December 23, 2022

***Subject: 3rd Review Completion Letter  
 Koneru Short Plat, File No. SUB21-008  
 PACE Project No. 21436***

SHEET **C1.0**

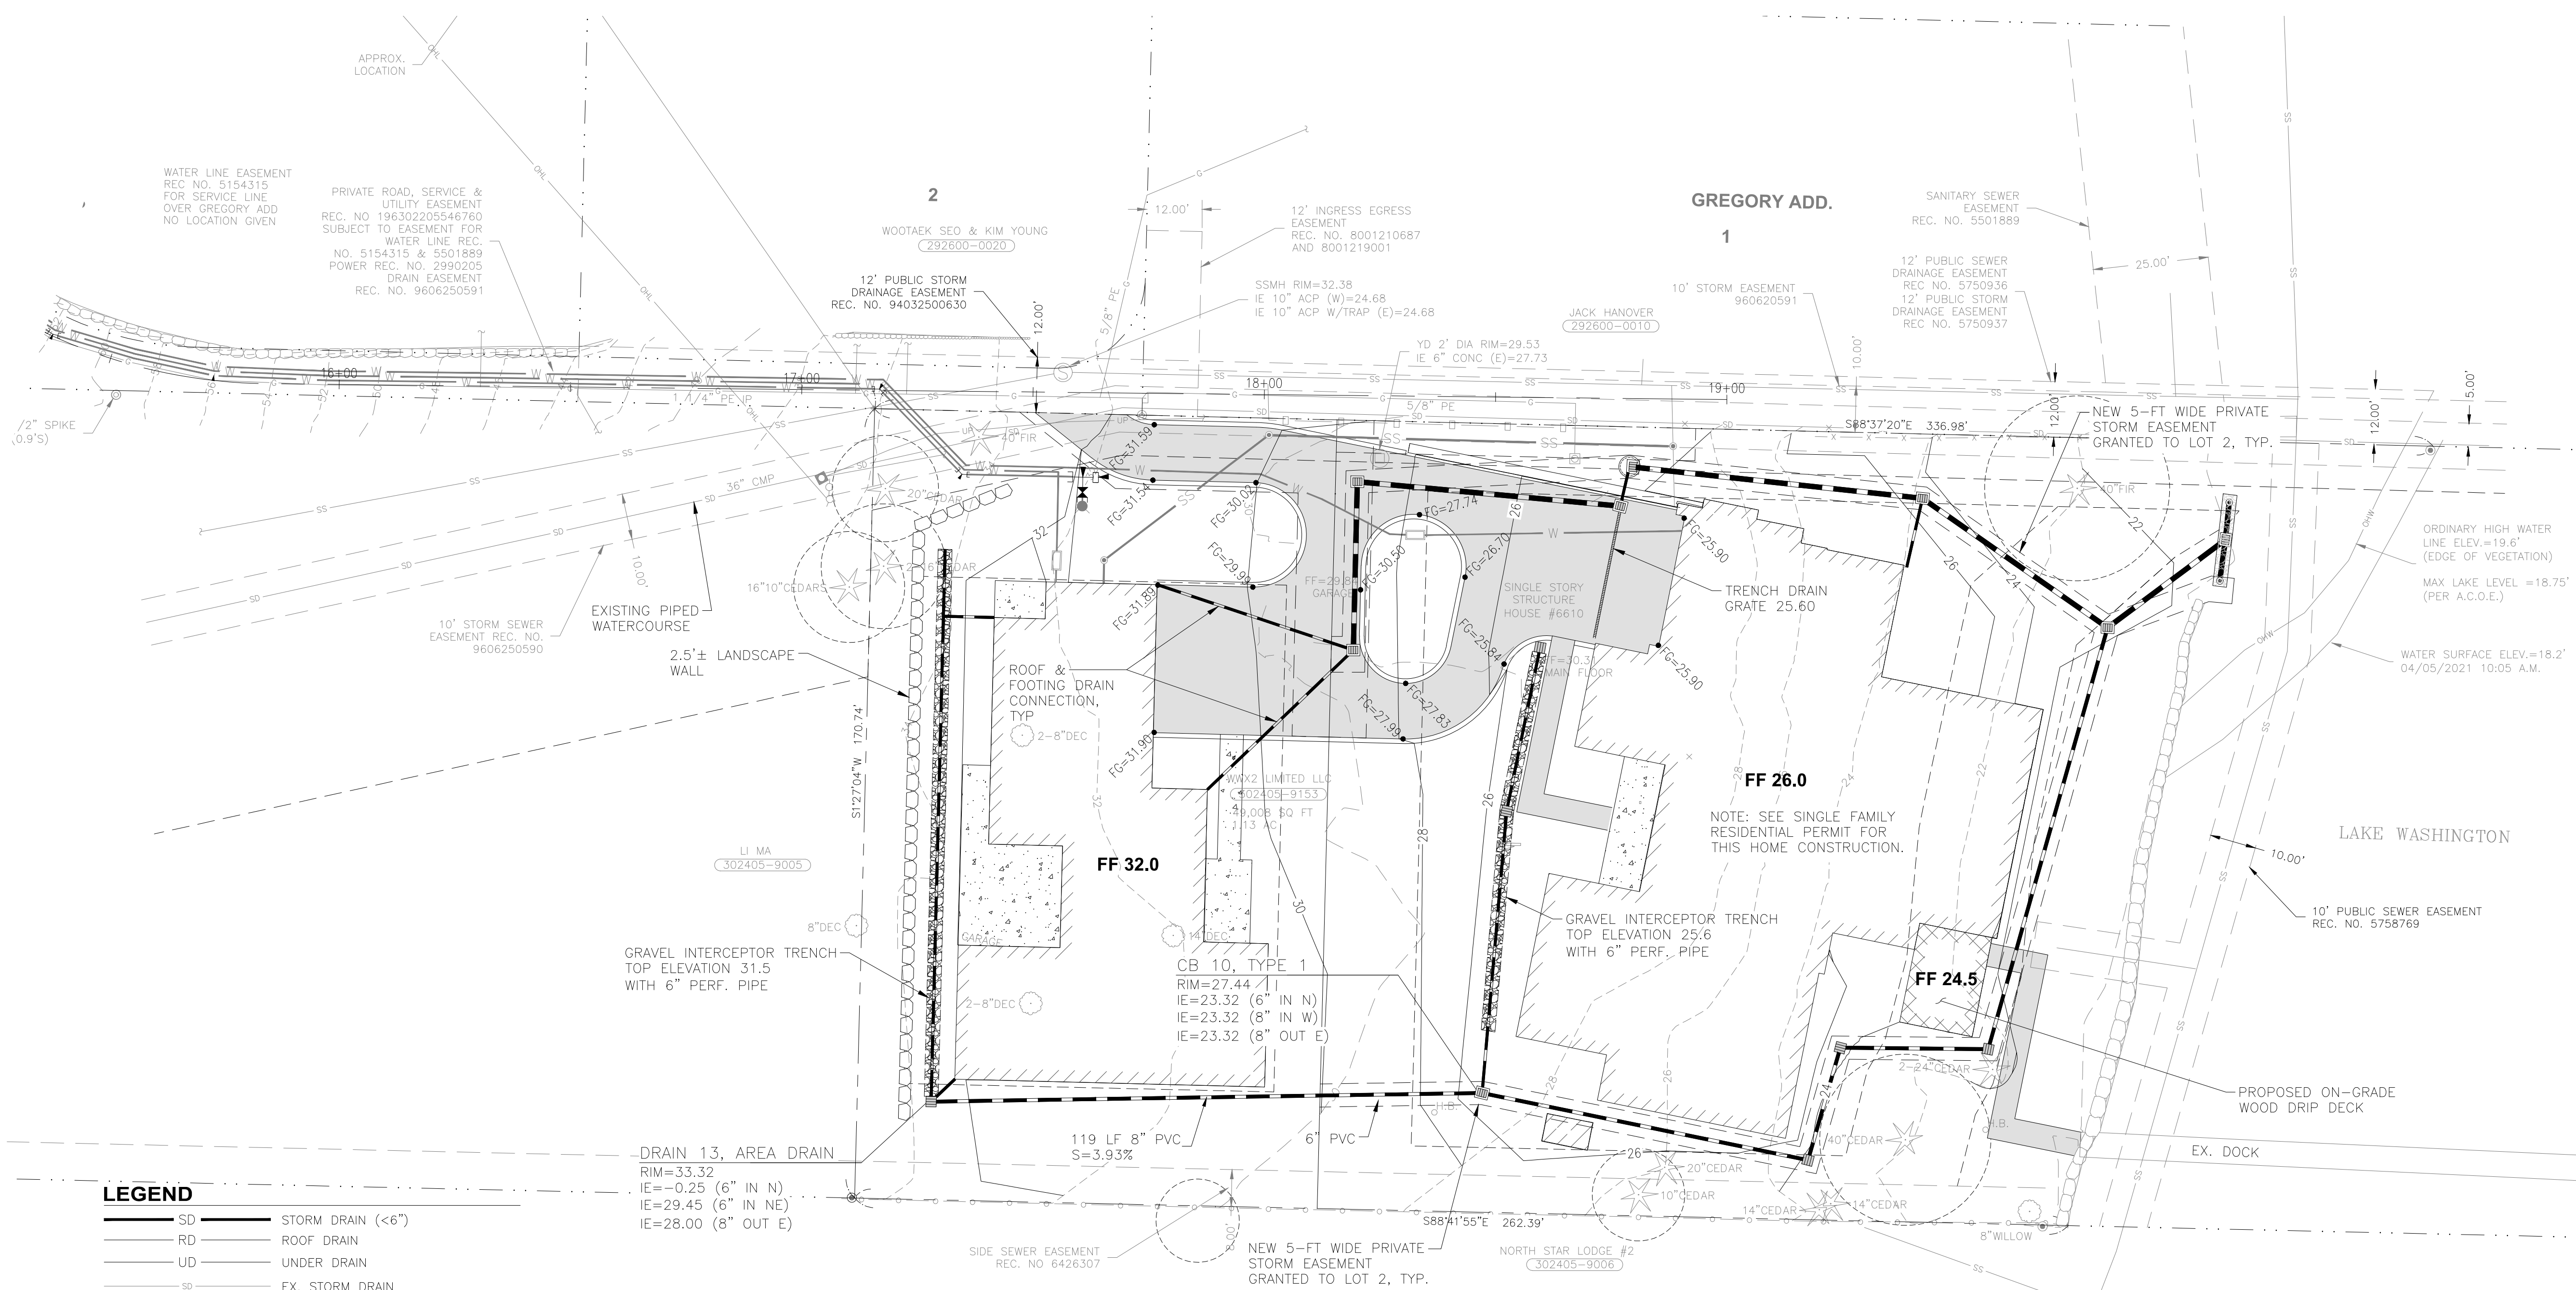
2. There is an existing public sewer easement onsite near the shoreline with recording number 5501889, please show on the plan.

4. Please clarify if the 5-ft storm easement near the northern property line is private or public, and proposed or existing.

5. Please clarify if the 7-ft side sewer easement for Lot 2 granted to Lot 1 is private.

6. Please clarify if the new 16-ft wide shared access and utility easement is private.

7. Please clarify if the access easement for Lot 1 granted by Lot 2 is private, also provide dimensions and limits of this easement. The submitted plan does not show the limits, only the call out.

1. The plat map needs to have the statement from the fire marshals office placed on it.  
*“All building permits are subject to meeting current fire code requirements at the time of a complete submittal, including fire apparatus access as outlined in adopted code sections of the International Fire Code Appendix D. Fire plan reviews will be conducted at time of building permit submittal and may require additional fire protection systems and/or additional fire prevention measures for building approval.”*

***PACE Response: Easement 5501889 is located on Gregory Addition Lot 1 (offsite lot to the north). It is shown on the existing condition map and site plan.***

***PACE Response: The 5-ft storm easement is private. Any easement callout that states granted by Lot 1 (or Lot 2) to Lot 2 (or Lot 1) is a new private easement for the proposed Koneru Short Plat lots. Private or public has been added to all easement callouts.***

***PACE Response: Any easement callout that states granted by Lot 1 (or Lot 2) to Lot 2 (or Lot 1) is a new private easement for the proposed Koneru Short Plat lots. Private or public has been added to all easement callouts.***

***PACE Response: Any easement callout that states granted by Lot 1 (or Lot 2) to Lot 2 (or Lot 1) is a new private easement for the proposed Koneru Short Plat lots. Private or public has been added to all easement callouts***

***PACE Response: Any easement callout that states granted by Lot 1 (or Lot 2) to Lot 2 (or Lot 1) is a new private easement for the proposed Koneru Short Plat lots. Private or public has been added to all easement callouts***

***PACE Response: The note has been added to the cover page C0.0, just above the callout for “call before you dig” and C1.0 Preliminary Short Plat.***

**C3.0**

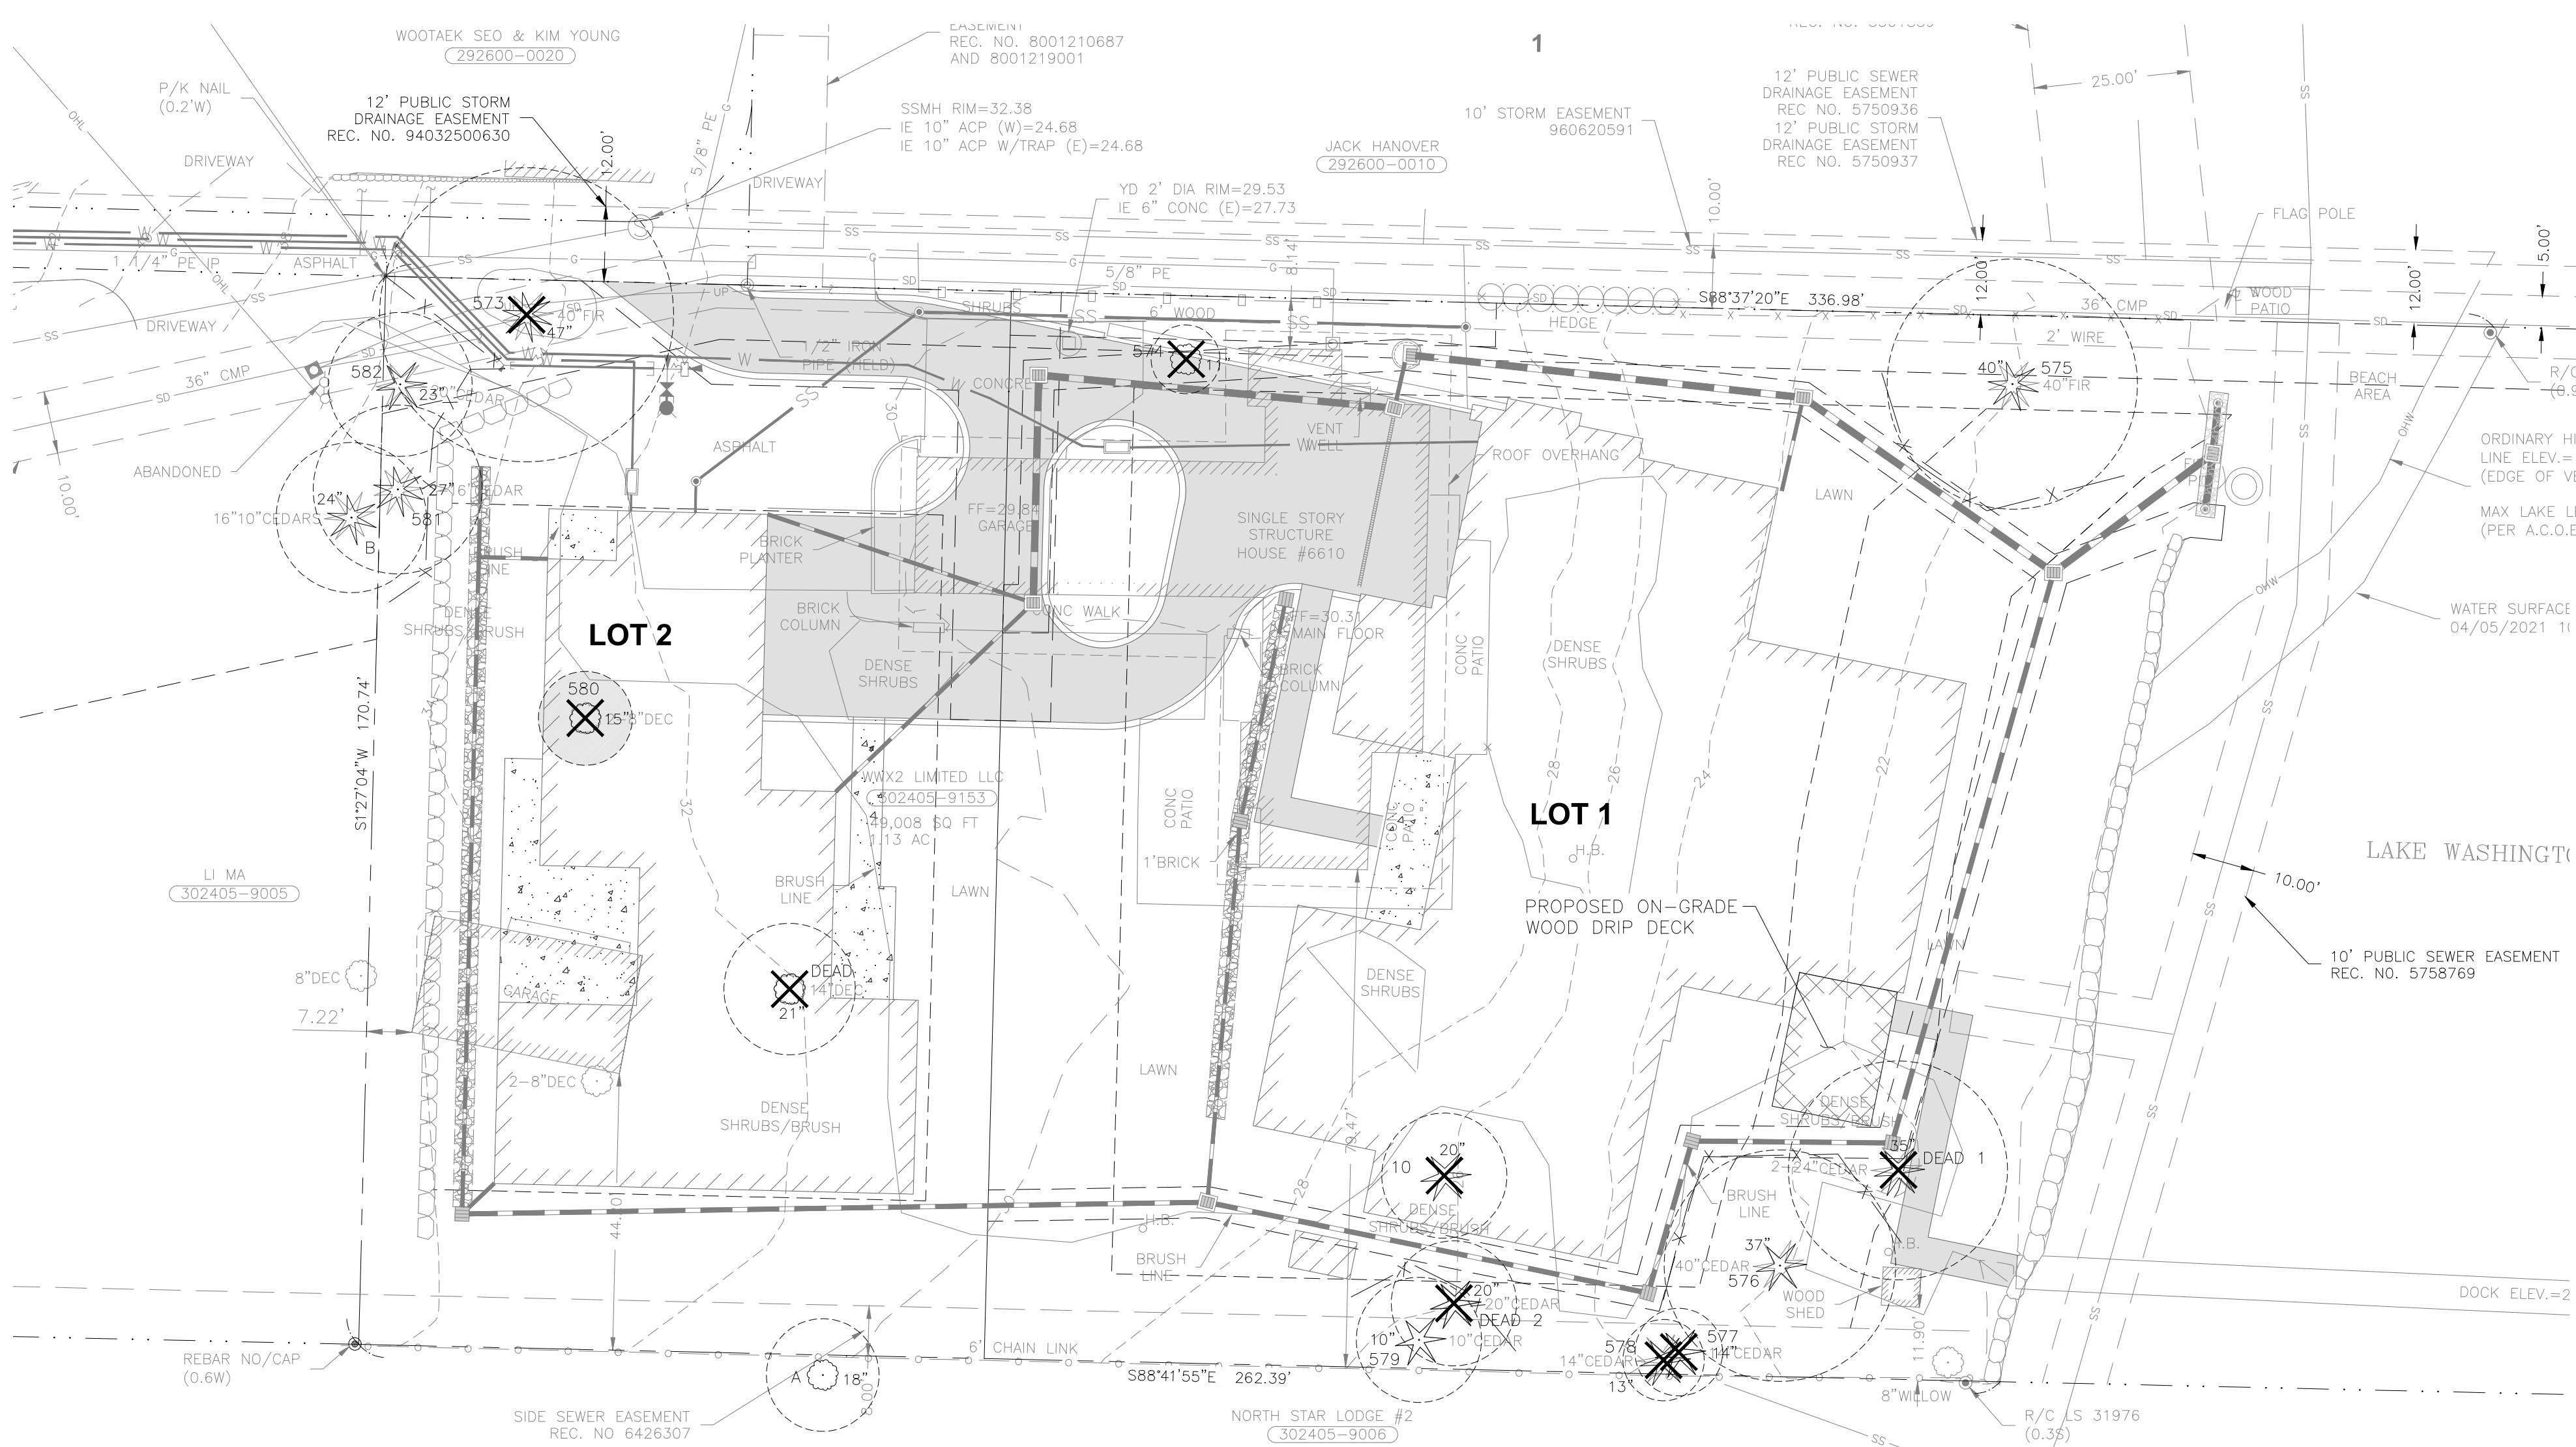
1. (Repeat comment for Architect/Arborist) Provide the tree inventory worksheet and include all trees removed within five years. This will include the trees that were approved to be removed under the non-development tree permit before this development proposal. This was for five trees to be removed under permit 2104-048 (trees 6,7,8,10,15 in previous report). The tree protection plan must show at least 30% of trees being protected and not damaged by construction for this subdivision to be approved.  
[https://www.mercerisland.gov/sites/default/files/fileattachments/community\\_planning\\_amp\\_development/page/21988/mercerislandtreeinventory.pdf](https://www.mercerisland.gov/sites/default/files/fileattachments/community_planning_amp_development/page/21988/mercerislandtreeinventory.pdf)

2. (Second repeat comment for arborist/civil) Update Arborists tree report, a draft report has been submitted. Arborist will need to review new plans and confirm the distance of disturbance is adequate and will not damage the saved tree.

***PACE Response: The plans show Tree Retention information approved for the single-family lot (2112-250) with the exception that tree 580 will be removed. See arborist report included with submittal.***

***PACE Response: The plans show Tree Retention information approved for the single-family lot (2112-250) with the exception that tree 580 will be removed. See arborist report included with submittal.***
